Subject: FW: R/17/22/DOC - Acoustic fencing - 6 Manor Road, Rustington

From: Kate Giddings <kate.giddings@arun.gov.uk>
Sent: 22 February 2022 12:35
To: Anita Gardner <Anita.Gardner@arun.gov.uk>
Subject: FW: R/17/22/DOC - Acoustic fencing - 6 Manor Road, Rustington

'Unable to recommend discharge of condition 6 (acoustic fencing details) because the submissions do not provide sufficient information (for example, specifying the height(s) of product to be installed, demonstrating the calculated noise reduction, the position/location of the fencing).

ACOUSTIC FENCING

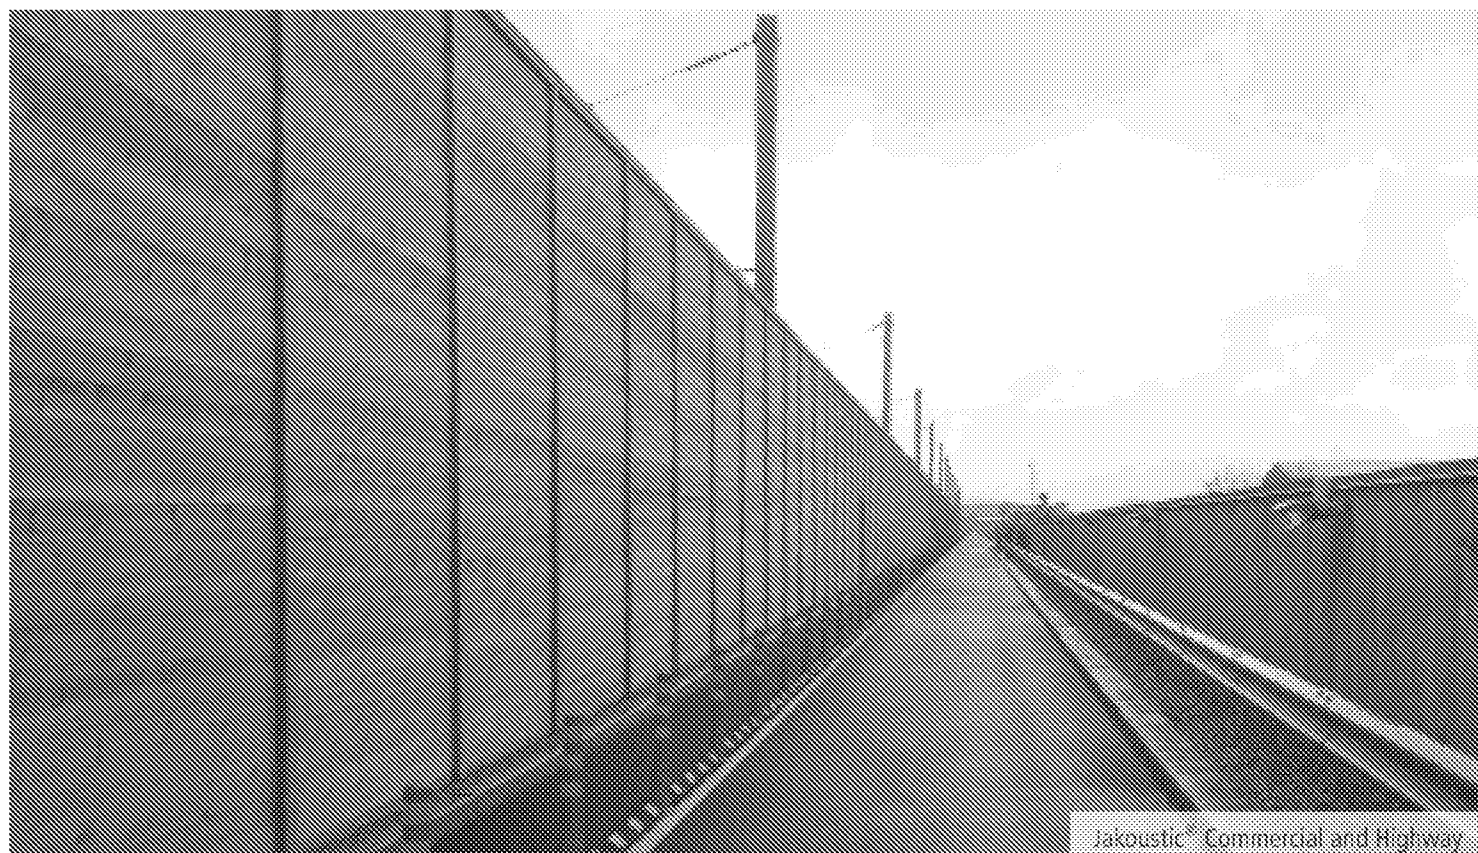
It is noted that the advertised 28dB reduction is under laboratory conditions, therefore results may differ slightly in the real-world situation. Furthermore and in contradiction to the written statement, a 28dB reduction is in fact less than the alleged 30dB reduction of the previous fencing option. Notwithstanding this, the submissions do technically satisfy the wording of the condition.
